London Luton Airport Expansion

8.127 Applicant's Response to Deadline 5 Submissions

Appendix C - Central Bedfordshire Council

Document Ref: TR020001/APP/8.127

Figure 3.10 2039 Updated runs – with vs without airport expansion

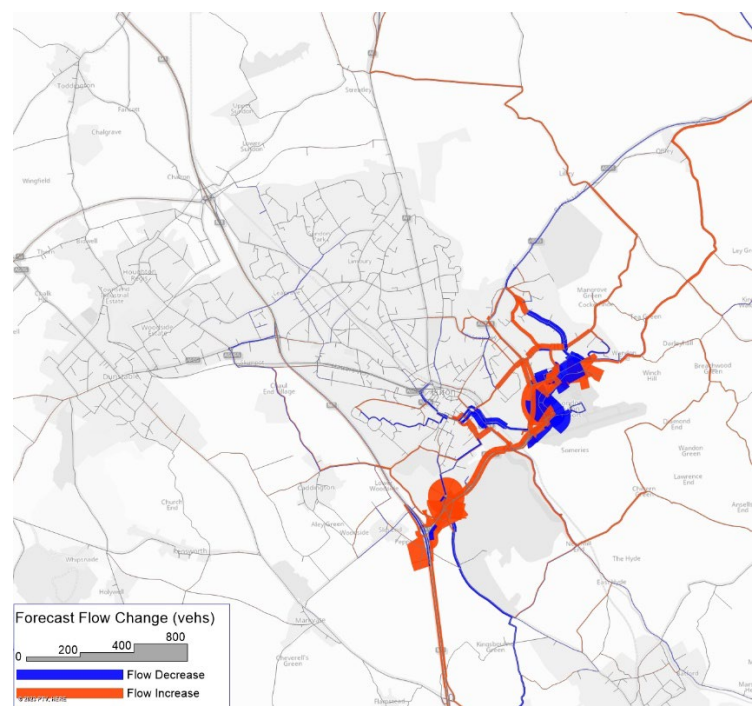
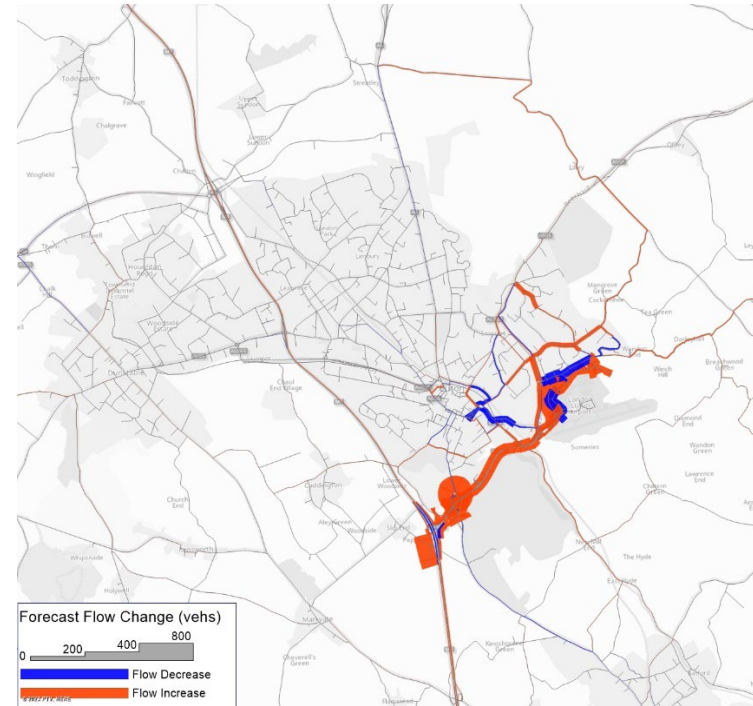
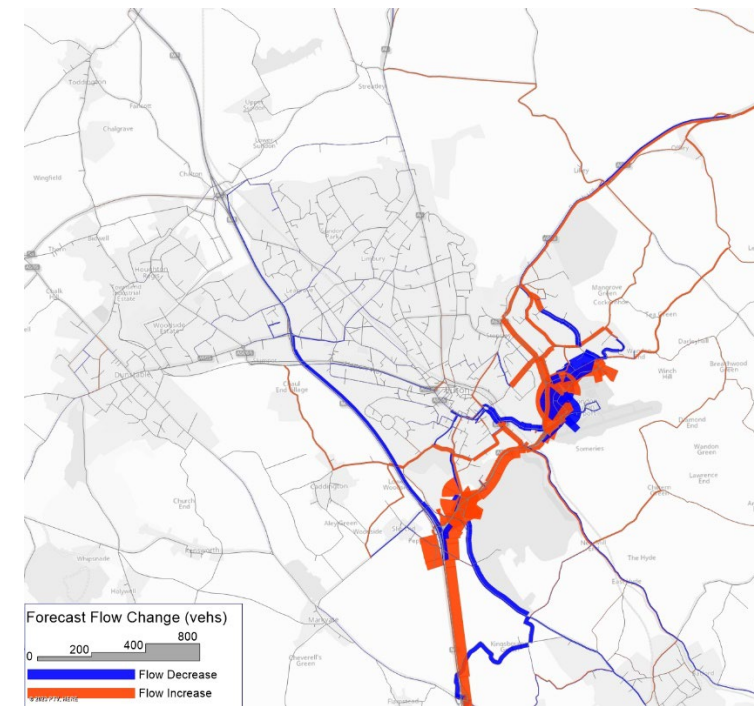
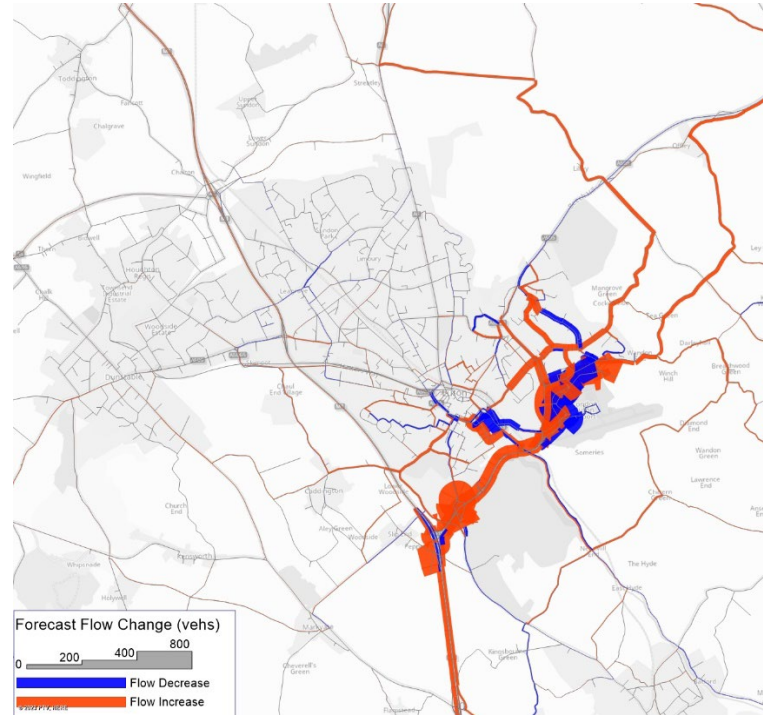
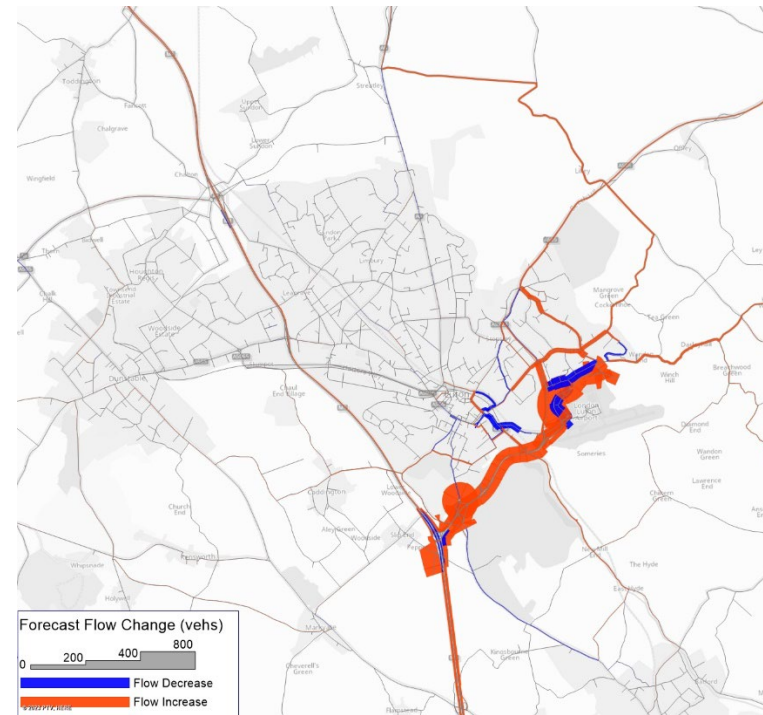
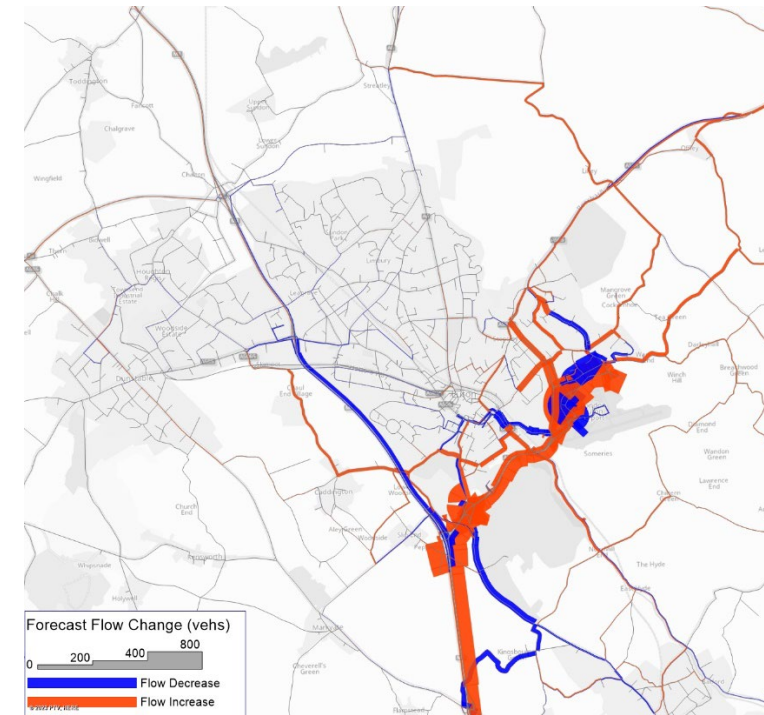
6	Surface Access	As detailed above, the information provided in Figures 2.7 to 3.12 does provide a helpful level of additional information, it is however difficult to fully identify the net changes between the two models without numbers assigned to the modelled links. CBC would therefore request a further set of difference plots with number assigned to links within CBCs network or tabulated flows for those links, and / or a plot showing the net difference between the two models (previous and updated). Following receipt of this information, and clarification of the above points, CBC would be in a	The Rule 9 'accounting for Covid-19 in transport modelling' work includes taking the updated strategic traffic modelling and further assessing the impact of the airport expansion via the VISSIM model and individual junctions modelling at key locations which include Caddington. The results of the VISSIM and individual junctions modelling will be reported in the Rule 9 final report.

Figure 3-1 Walk catchment

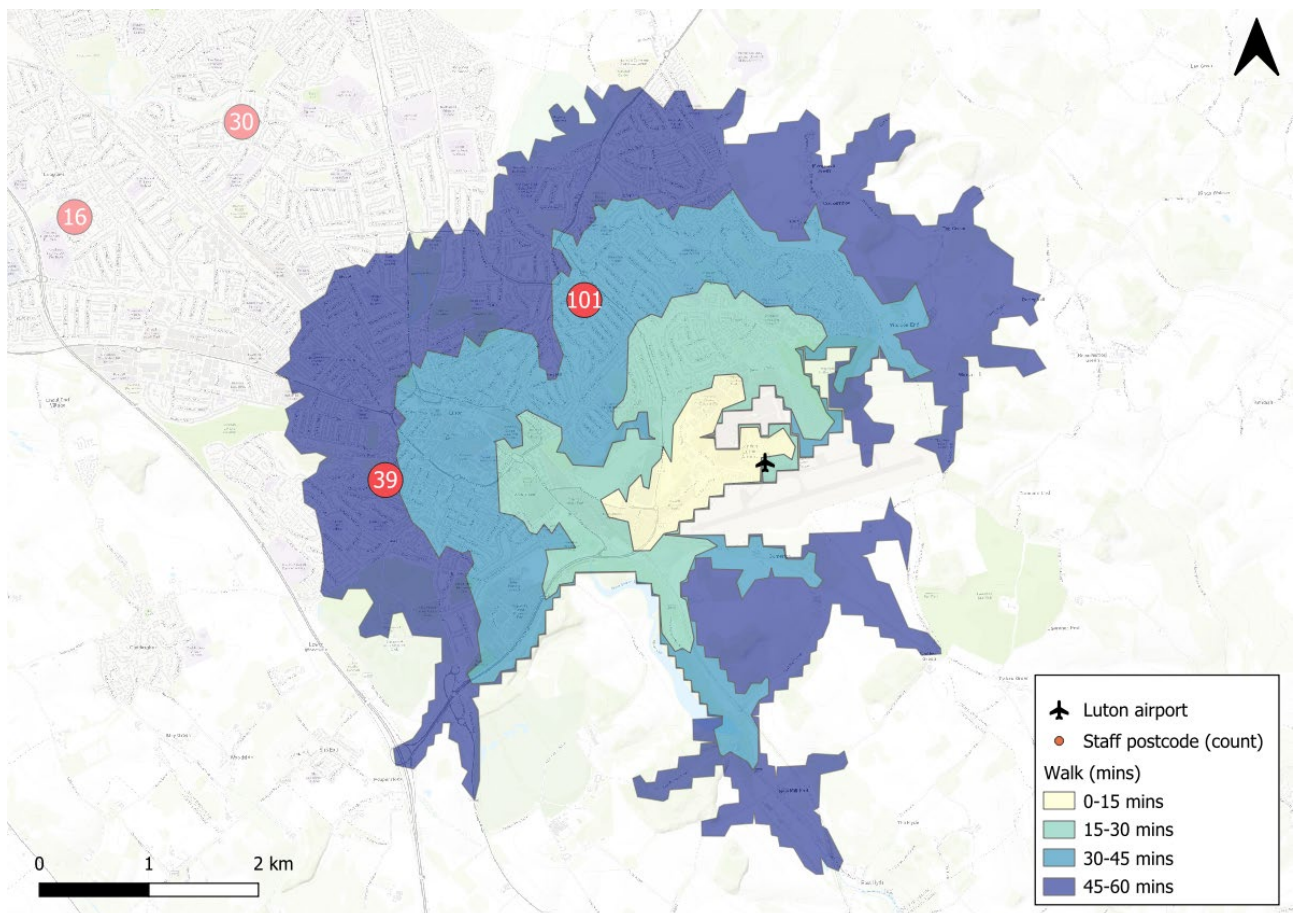
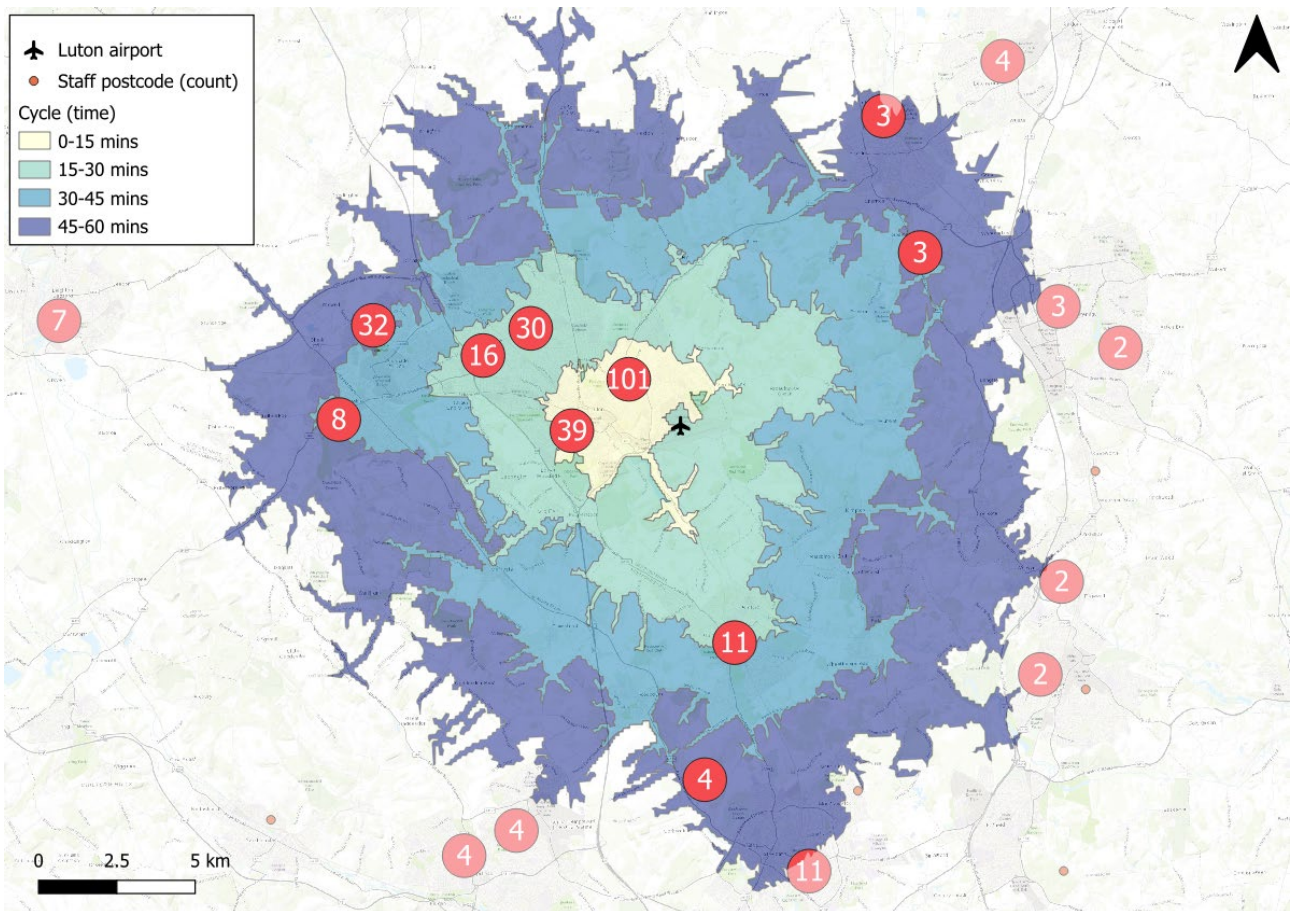
8	Surface Access	<p>REP4 – 084 - Applicant's Response to Issue Specific 4 Action 29: Catchment area for staff walking and cycling</p> <p>Whilst the majority of the measures to encourage staff to walk and cycle are likely to fall within the Luton Borough Council Authority area, there is a notable cluster of staff postcodes within the 30 - 45 minute banding provided as Figure 4.1, covering the Houghton Regis and Dunstable areas. This would generally appear to support the need for appropriate measures, whether based around cycling or public transport, to facilitate sustainable staff access to / from the Airport from these postcode areas. Whilst it is understood that it may be difficult to identify specific public transport routes, CBC would be seeking an acknowledgement of this demand and a commitment to include it within the measures to be reviewed through the Sustainable Transport Fund process.</p>	<p>The Applicant notes this. Future mitigation can be discussed through the Airport Transport Forum Steering Group – which Central Bedfordshire Council (CBC) are a named member of.</p>
